Lead Local Flood Authority

R/63/26/PL – Windmill Inn, 42 Mill Lane, Littlehampton, BN16 3JN

The scheme proposed does not currently meet Standard 1 Run Off and Standard 3 Extreme Rainfall and Flooding of the National Standards for Sustainable Drainage Systems (NSfS) and consequently conflicts with Local Policies WDM2 and WDM3, therefore, **we object** to the approval of the full app for the following reasons:

**Proposed Site Layout
and Positively Drained Areas Plan**

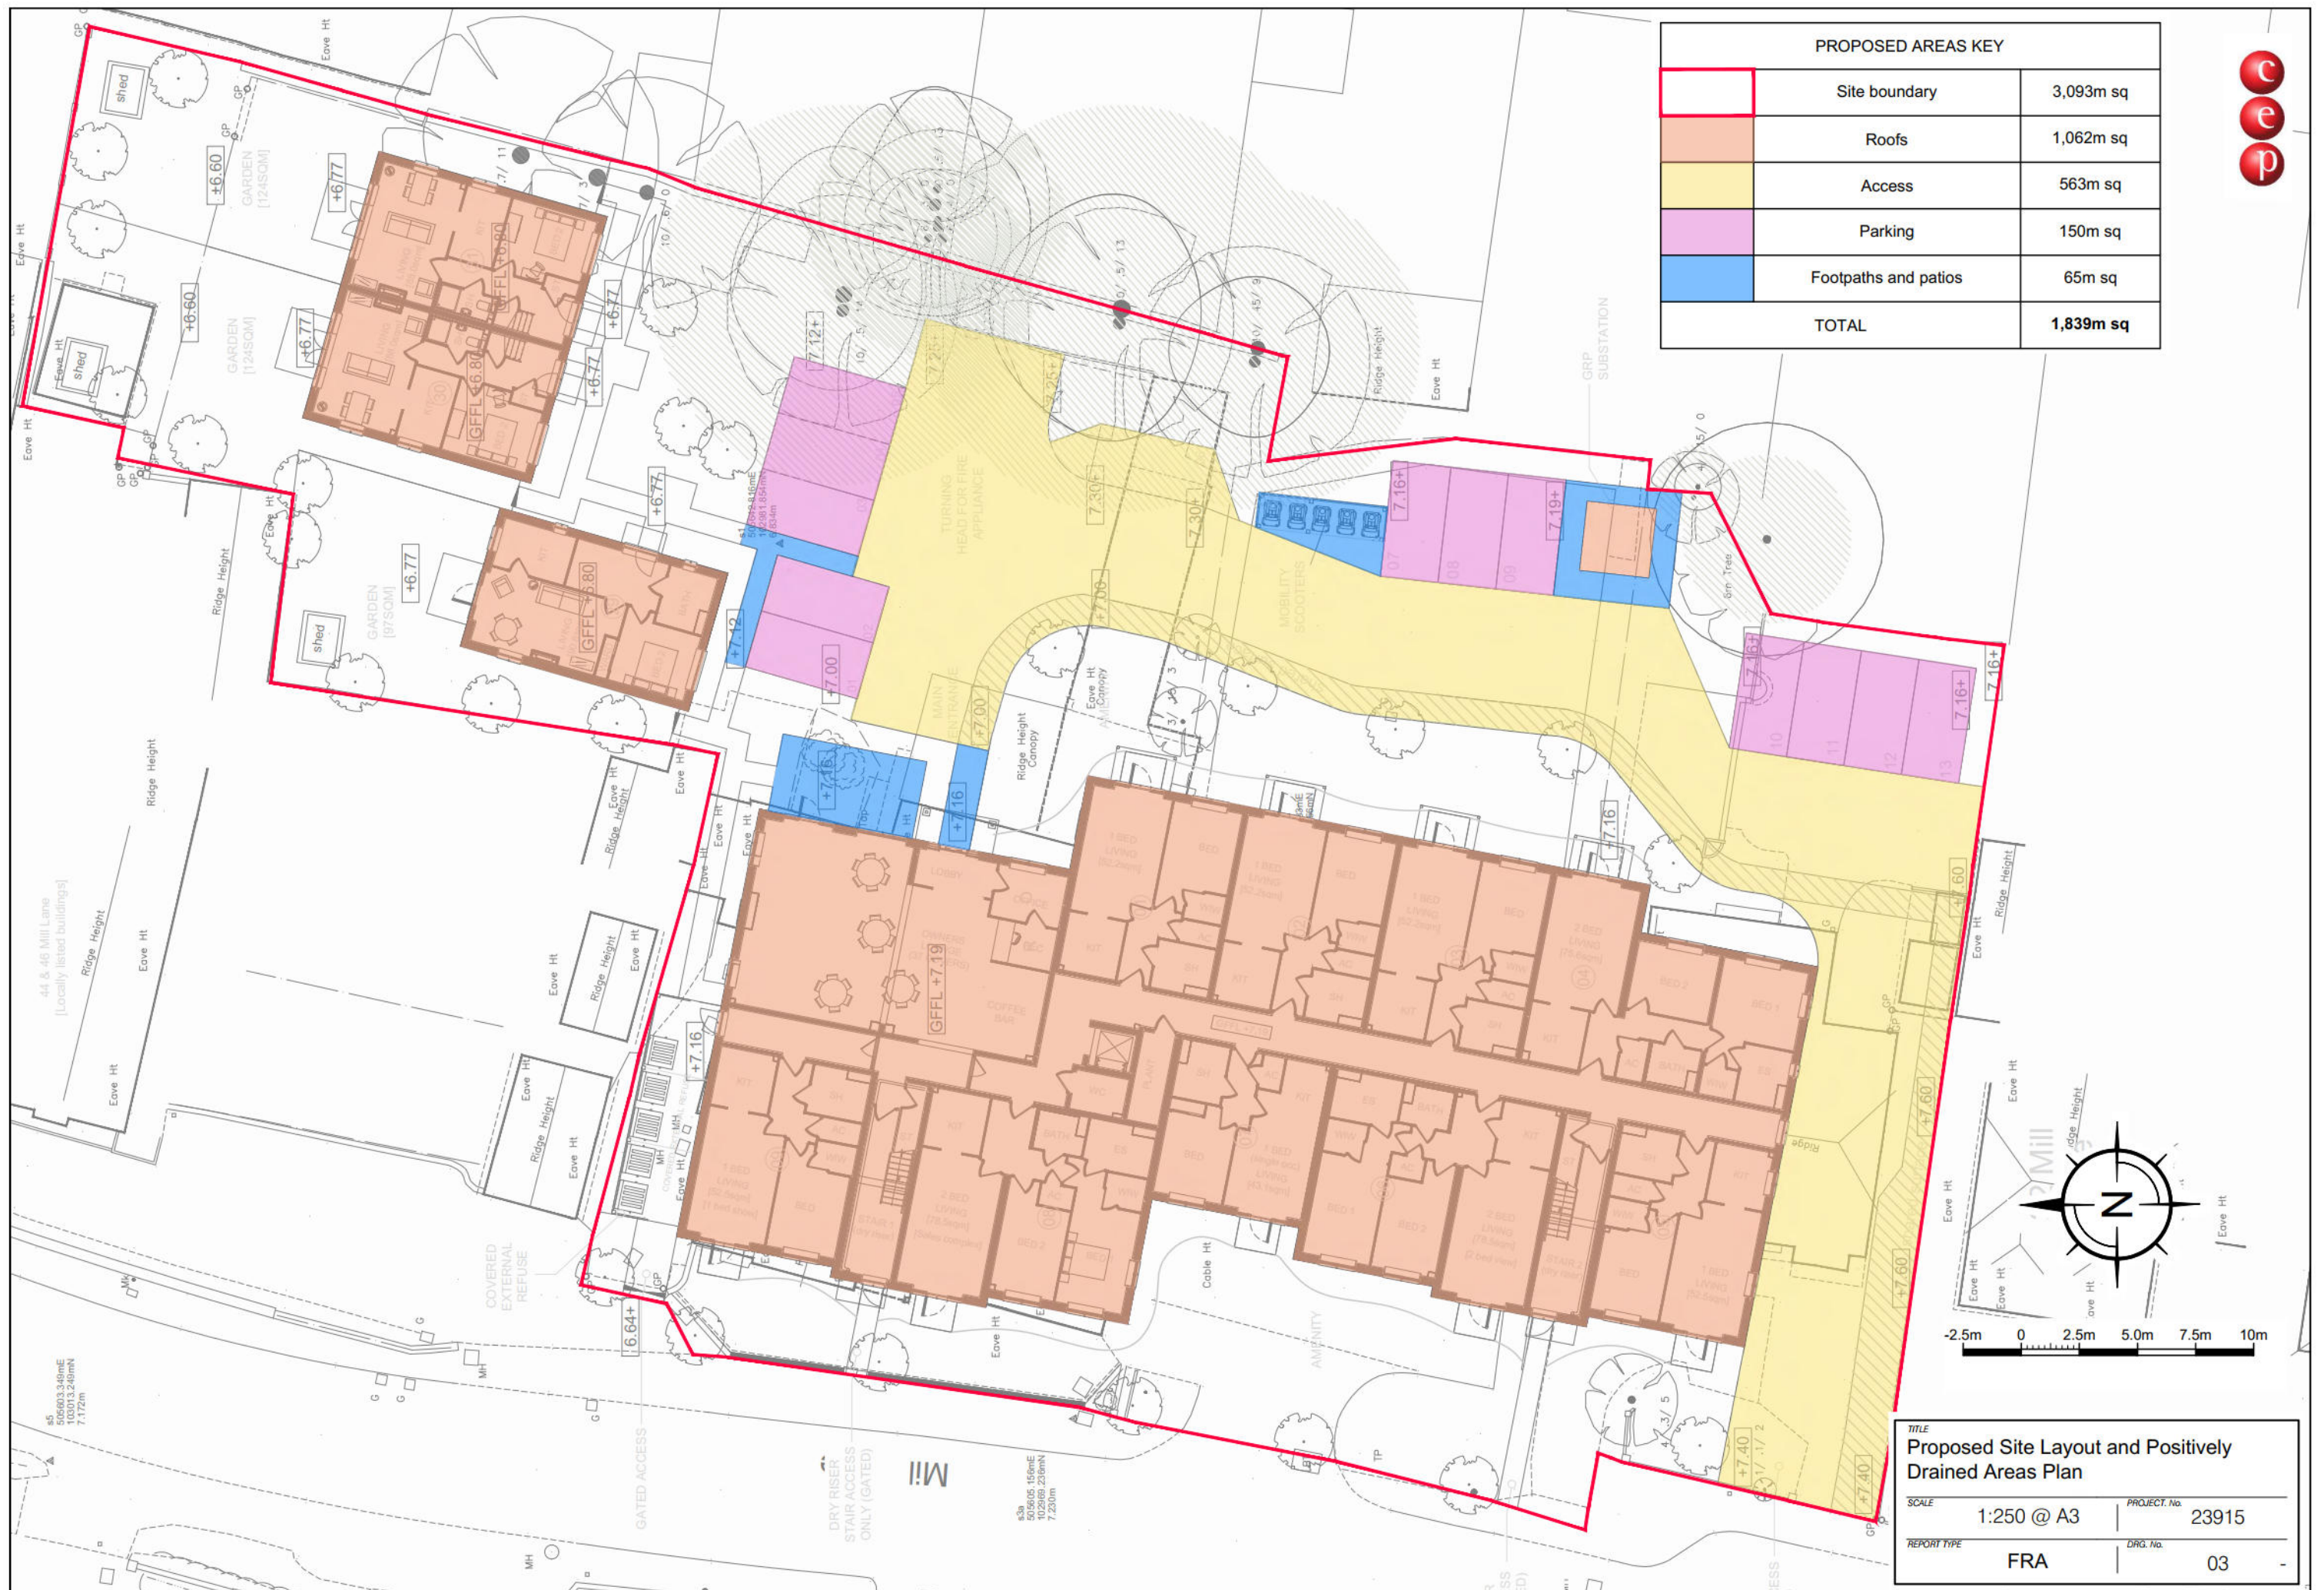
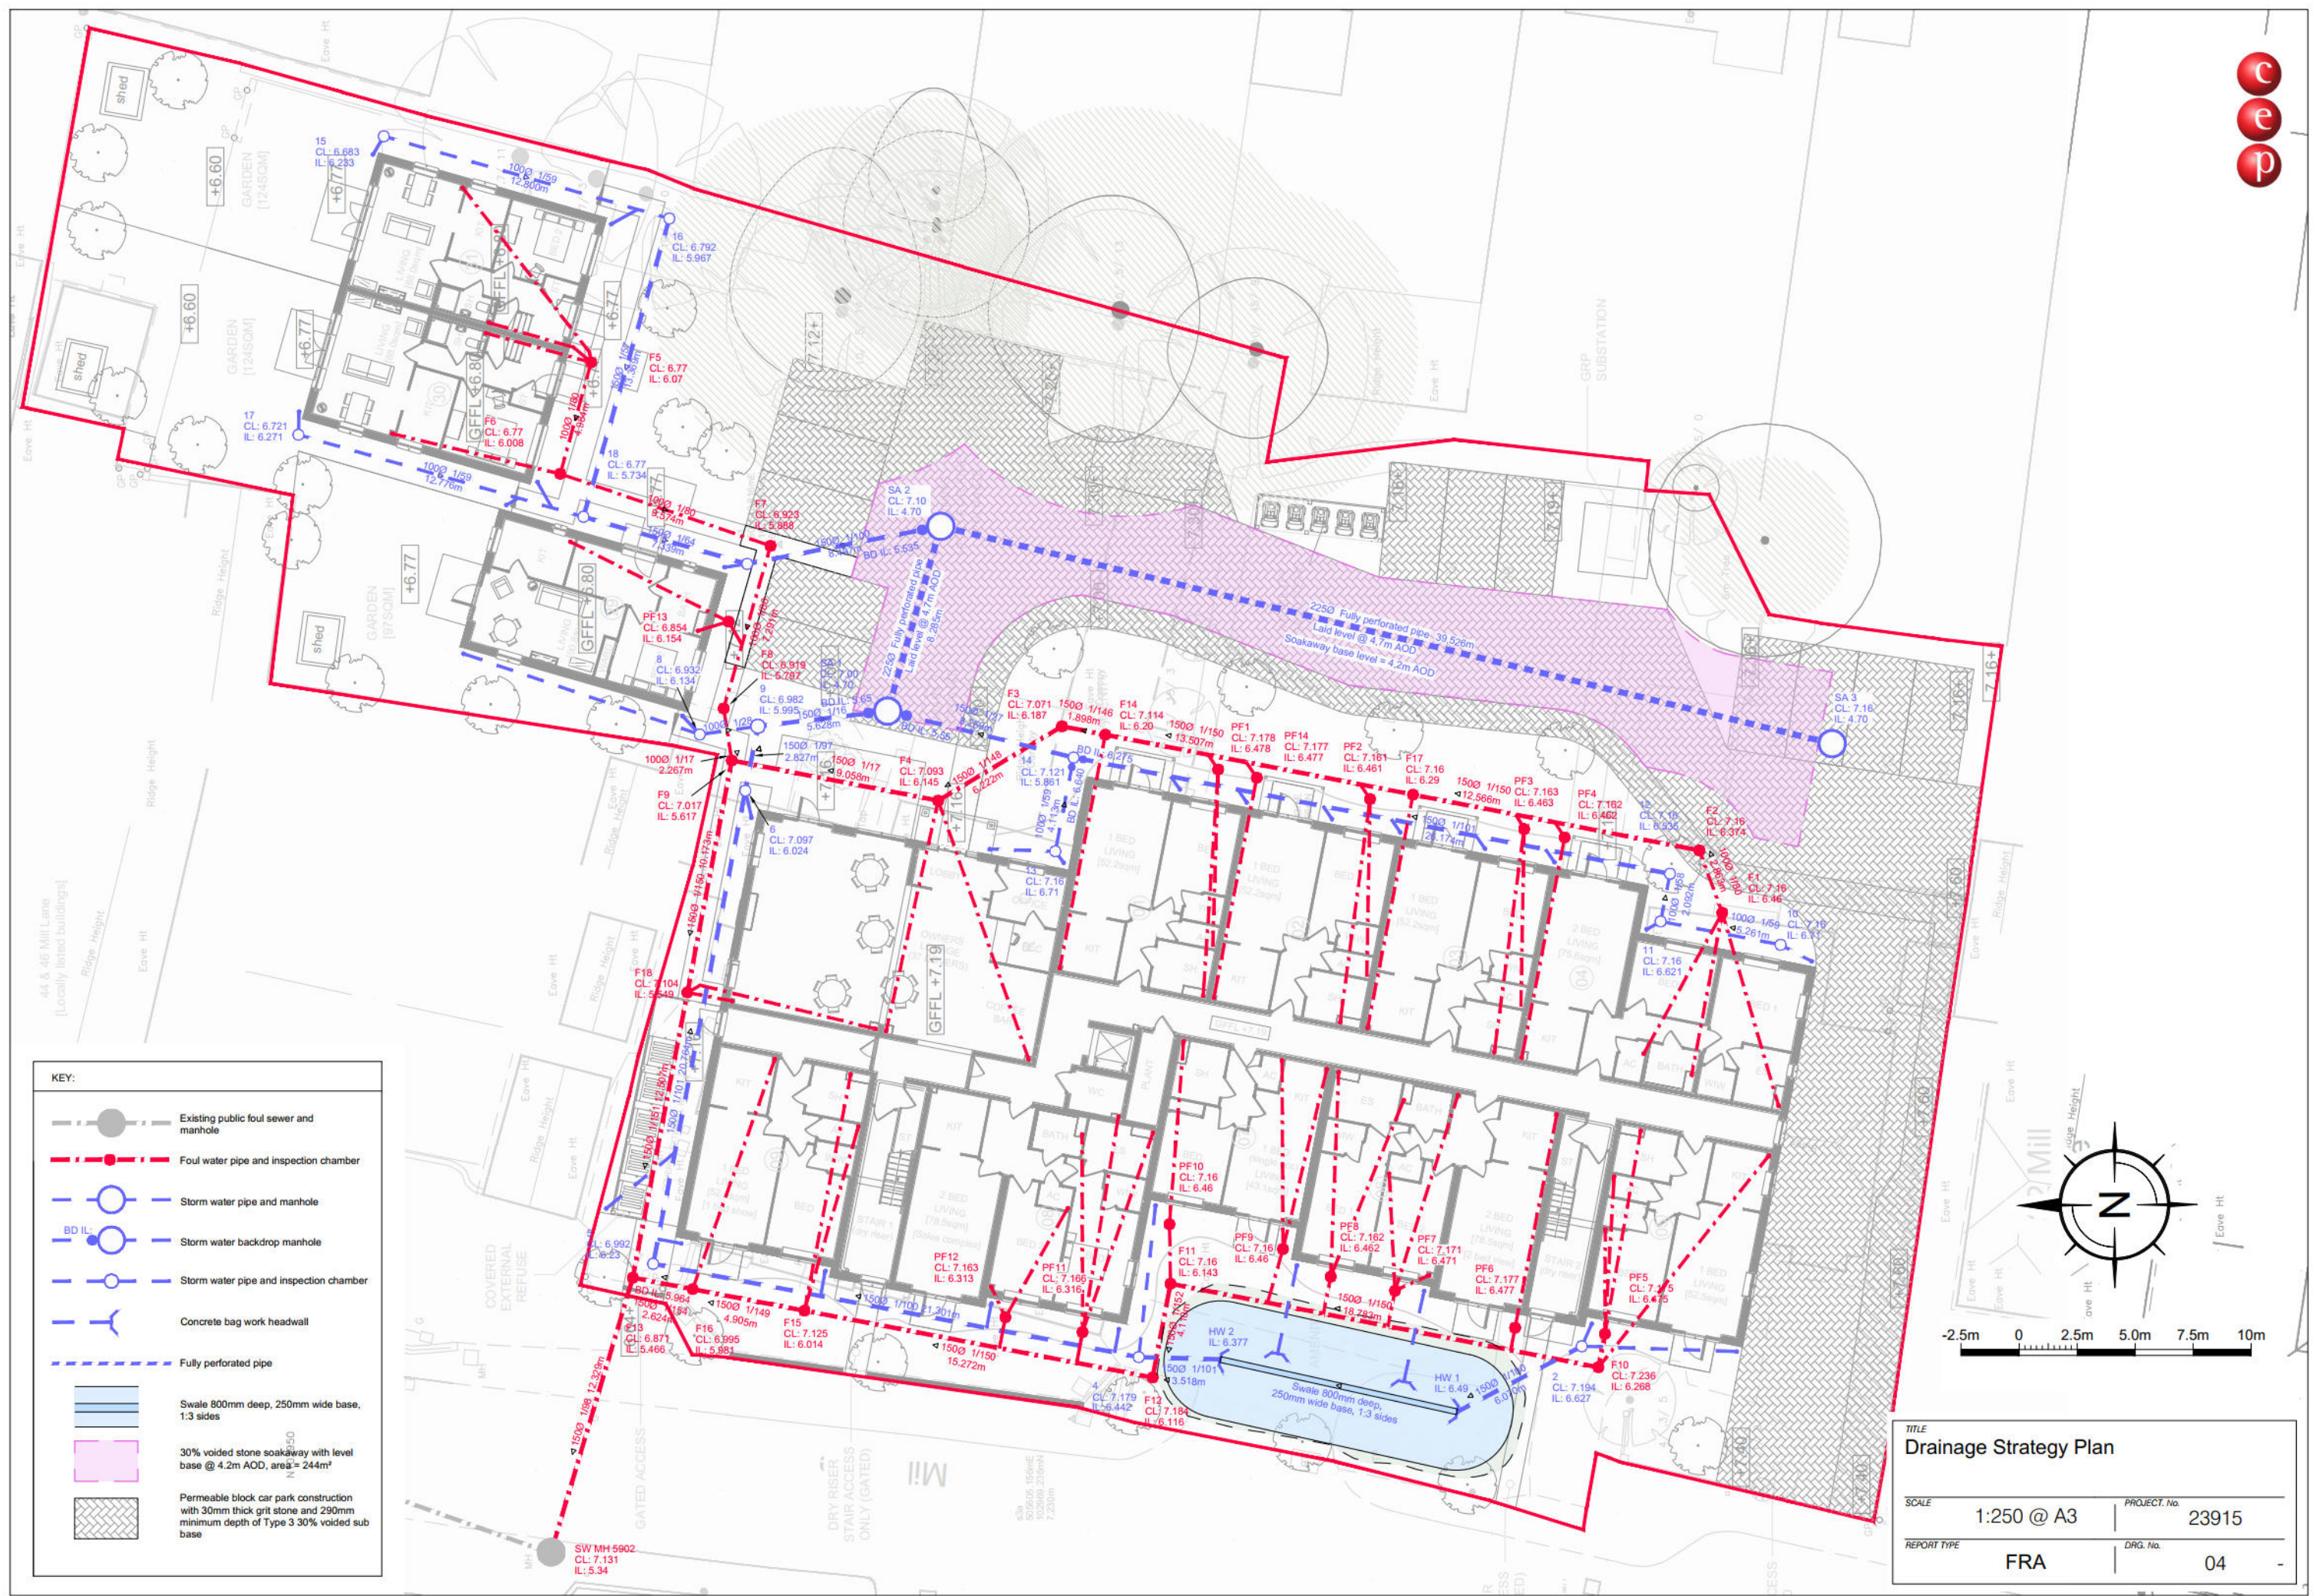
1. Reuse-is stated however no feature, scale or layout is shown.
2. 1 m buffer from the highest recorded ('Maximum likely') groundwater level is not achieved.
3. Percolation testing is required at the depth and location of any infiltration features. Additional testing will be required to account for achieving the required buffer from groundwater (Point 2). Calculations and designs will need to be updated in response to the results.
